CITY OF ALBUQUERQUE

PLANNING DEPARTMENT – Development Review Services

**RE: A Class Mega Storage
Grading and Drainage Plan
Engineers Stamp Date 4/30/14 (F15D52B)**

Based upon the information provided in your submittal received 5-1-14, the above referenced plan is approved for Building Permit with the following condition:

| | GRADING AND DRAINAGE PLAN | WWEZ_A0008_0001_PLAN.dwg |

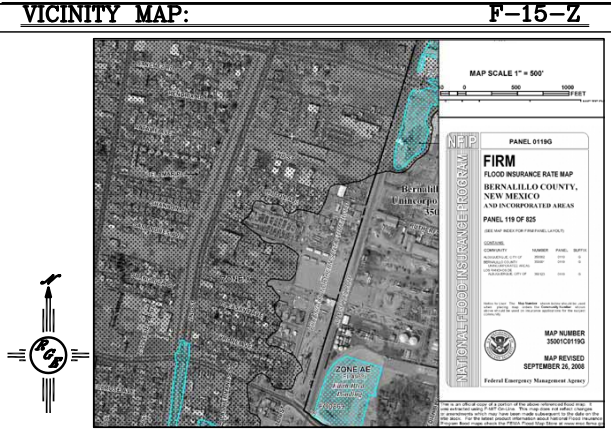
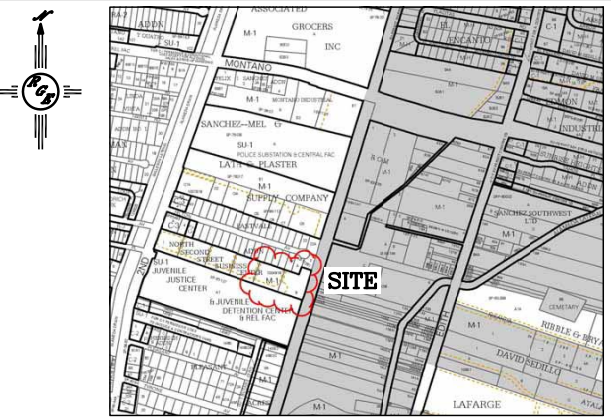
- Prior to Certificate of Occupancy, the As-built Grading and Drainage Plan must show that two spot elevations on the east side of lot, and just outside the units where the FF elevation changes from 95.33 to 96.00 ft are changed so that the FG slopes away from building. Per our phone conversation, the new spot elevations are to be 95.25 and 95.33.
